**EPC STORMWATER REVIEW COMMENTS
IN ORANGE BOXES WITH BLACK TEXT**

PRELIMINARY/FINAL DRAINAGE REPORT FOR PINE VIEW ESTATES

PRELIMINARY/FINAL DRAINAGE REPORT
PINE VIEW ESTATES

DRAINAGE MAPS

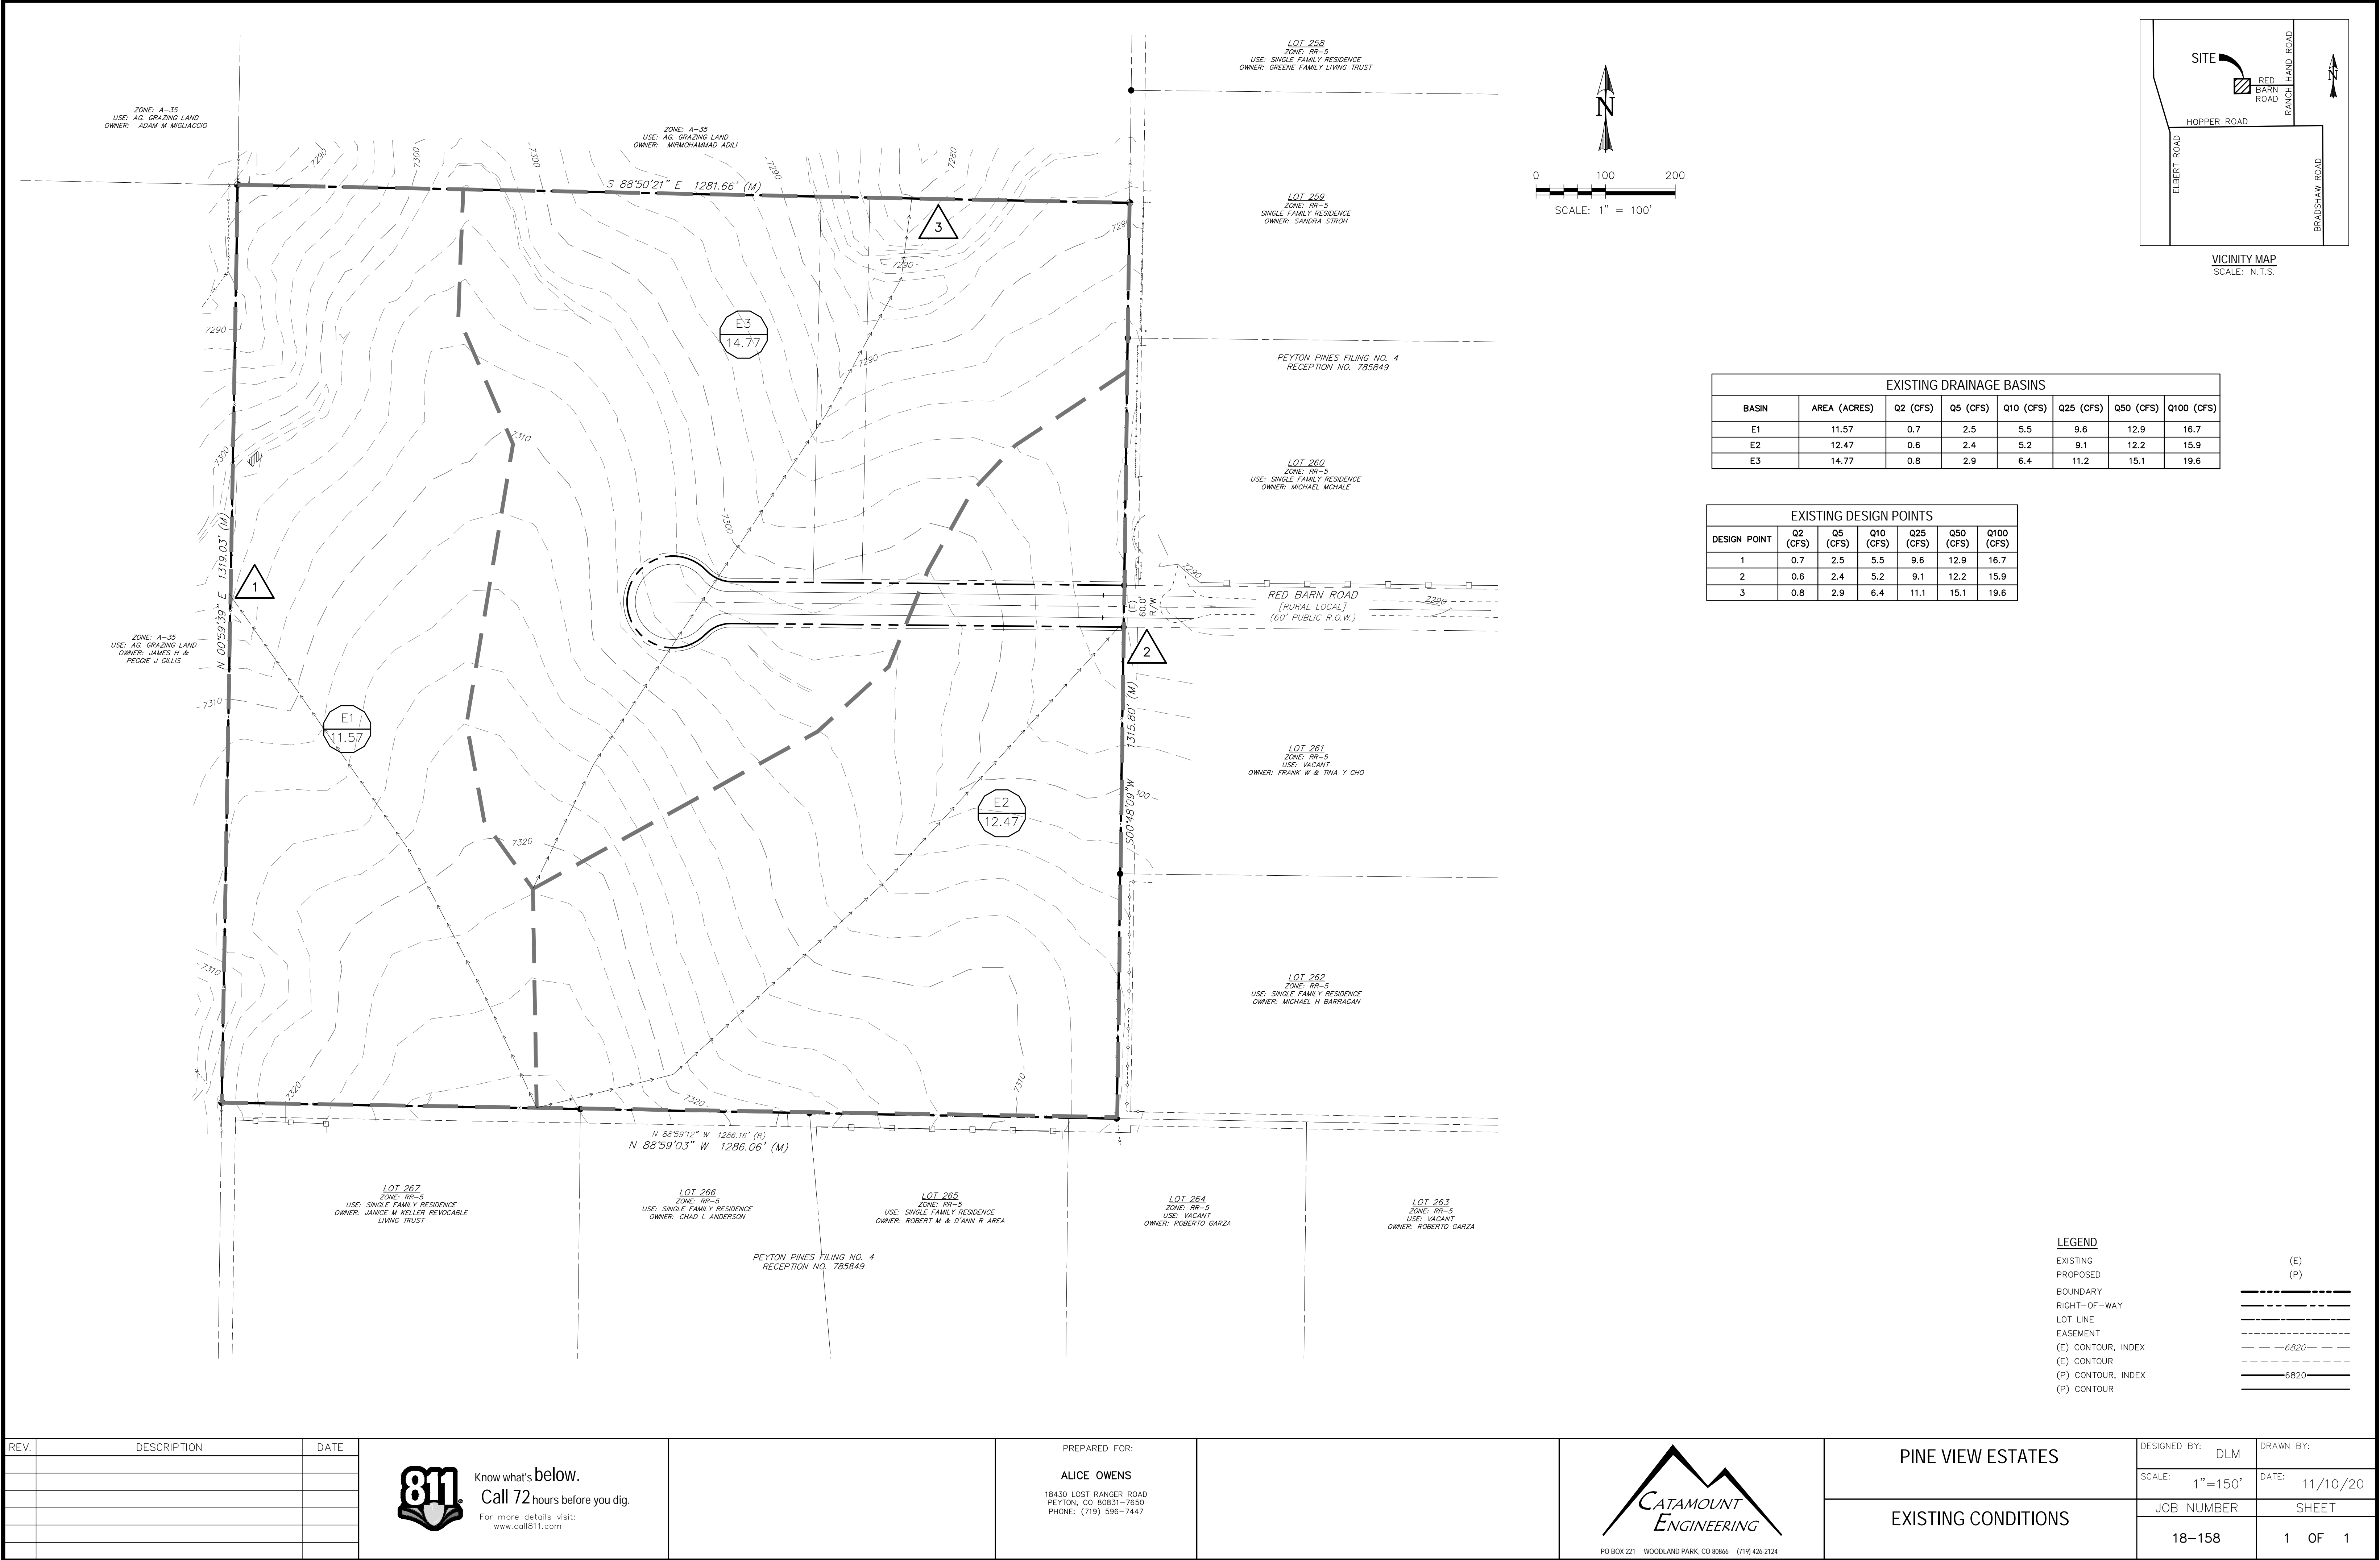
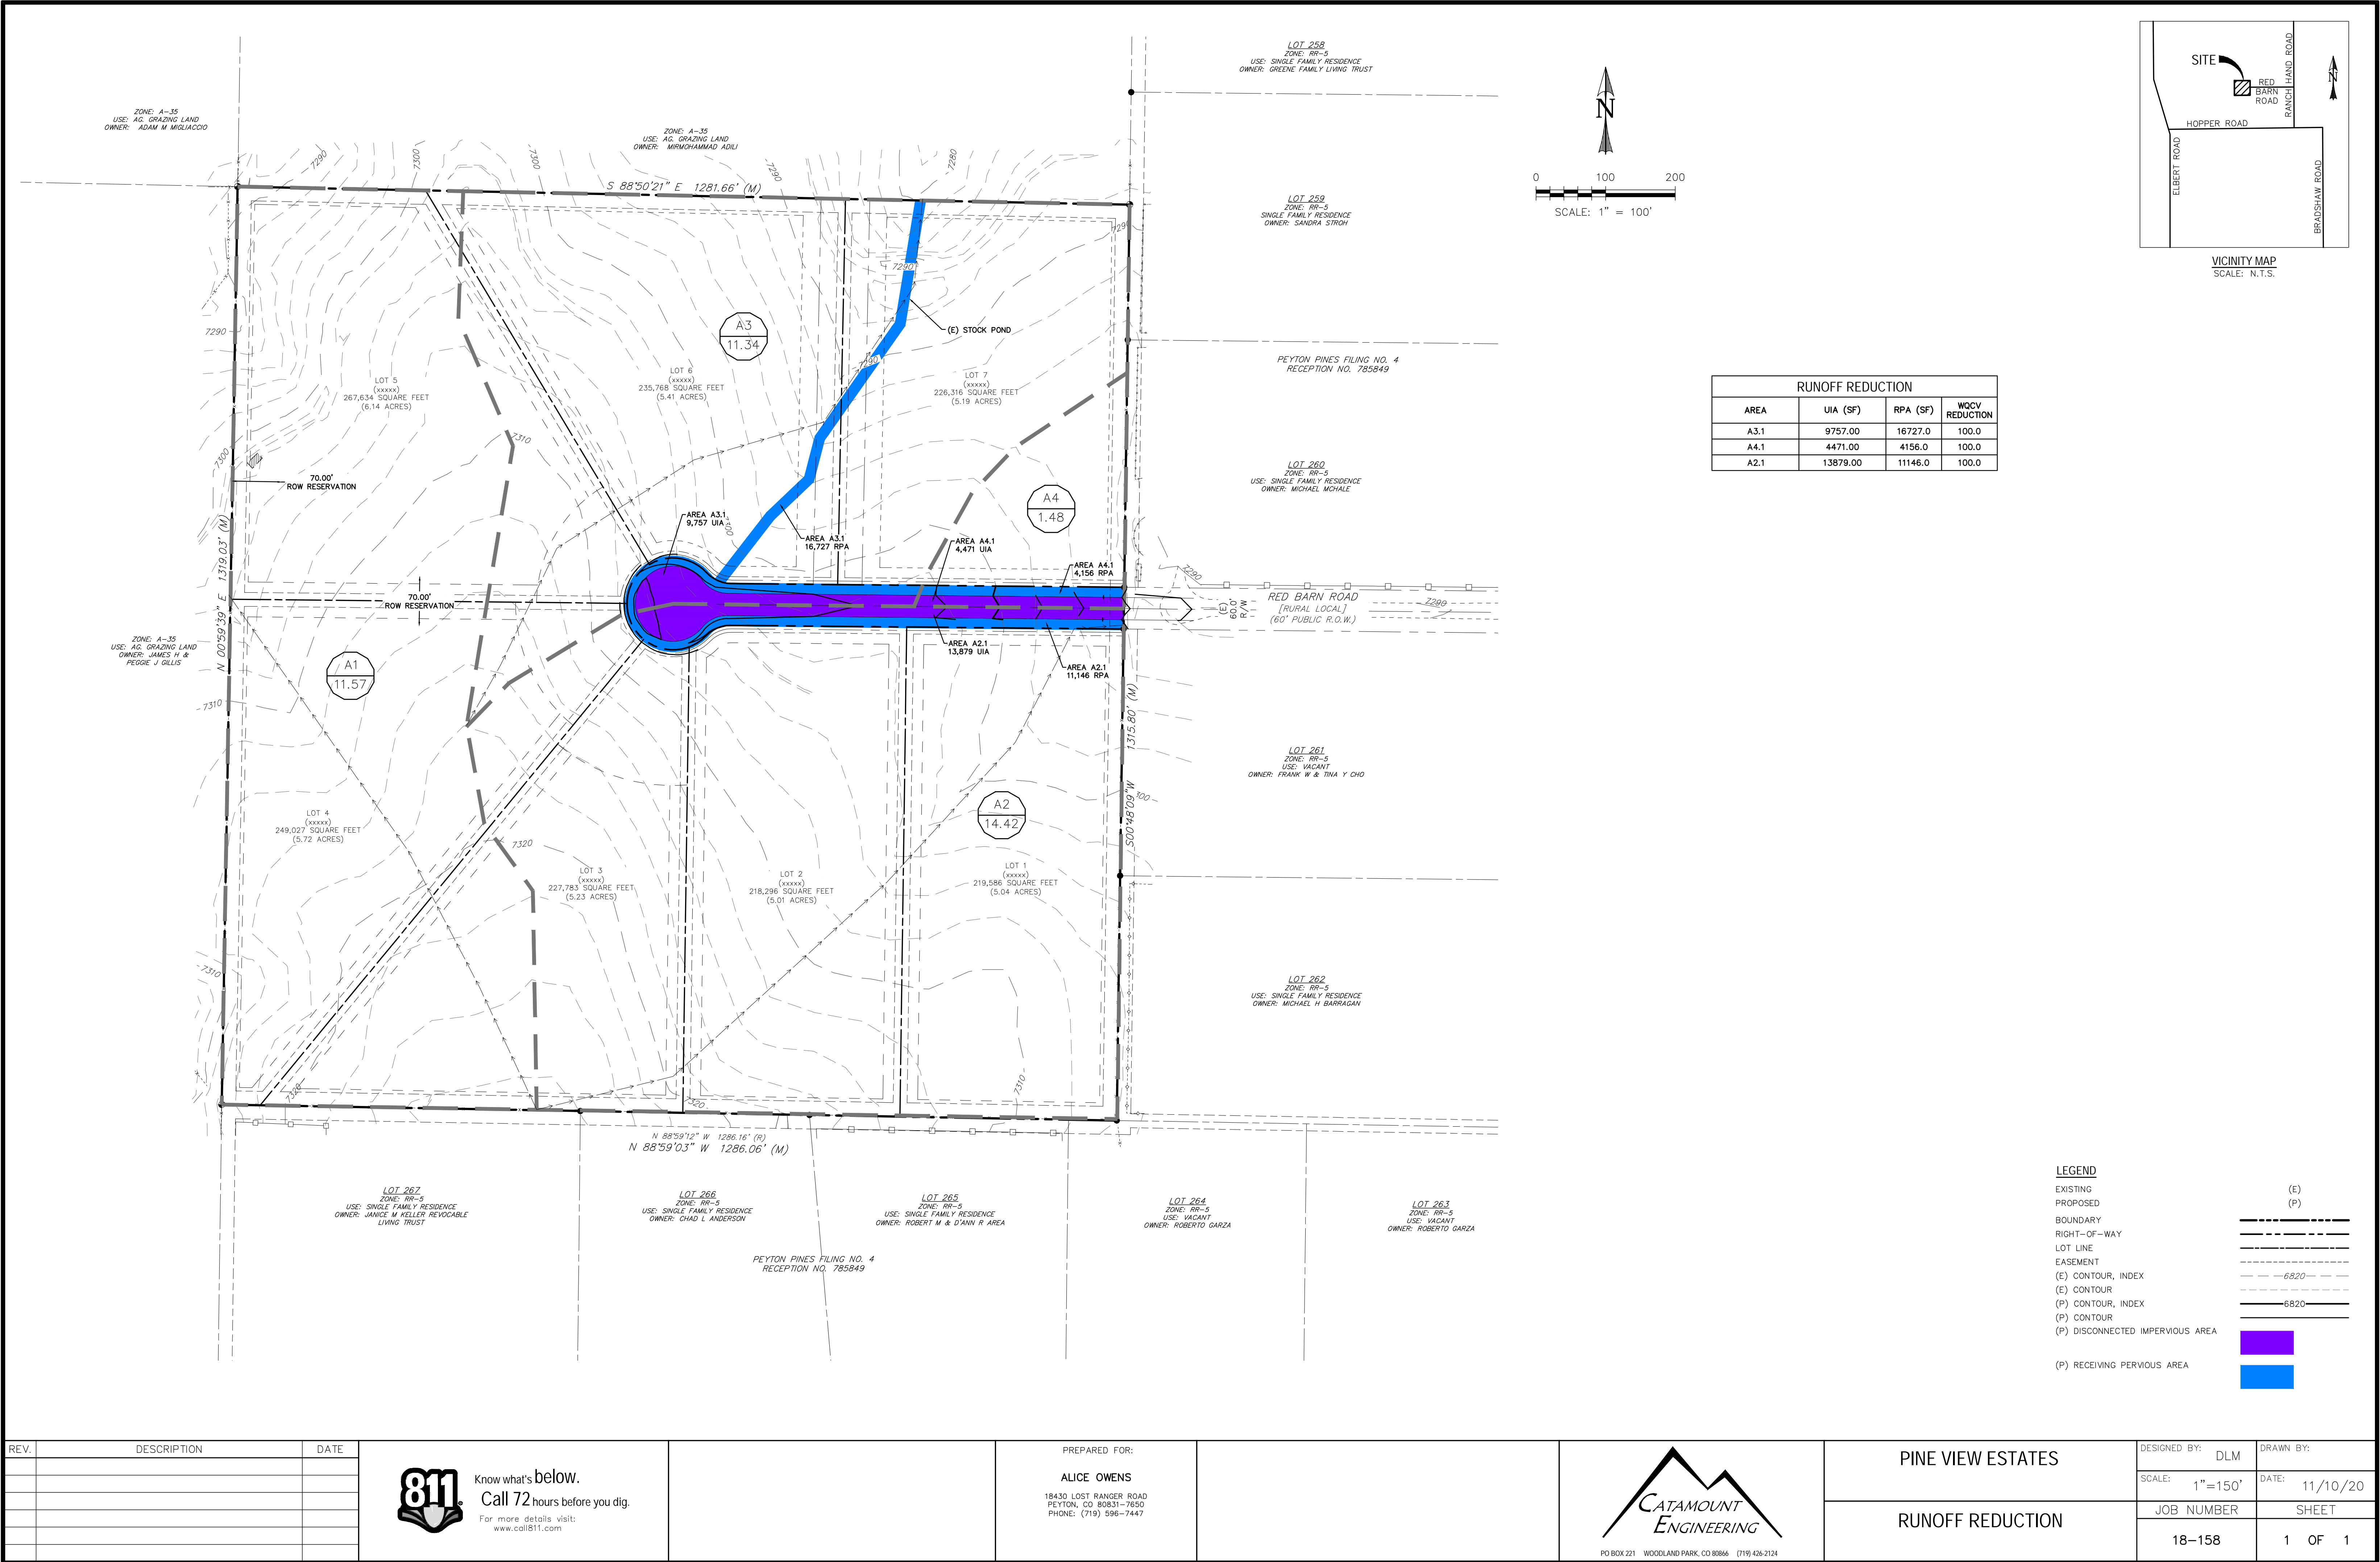
per your drainage plan it appears to flow to the northwest. Please revise

The northern half of the roadway will flow to the roadside ditch and flow easterly. Revise accordingly.

There is no mention of channel improvements in your narrative or shown on the drainage plan. Please revise.

REVISED
northeasterly per the drainage plan

ROADWAY RAISED
TO ALLOW SHEETFLOW
(NO DITCH)

REFER TO CHANNELS REMARK
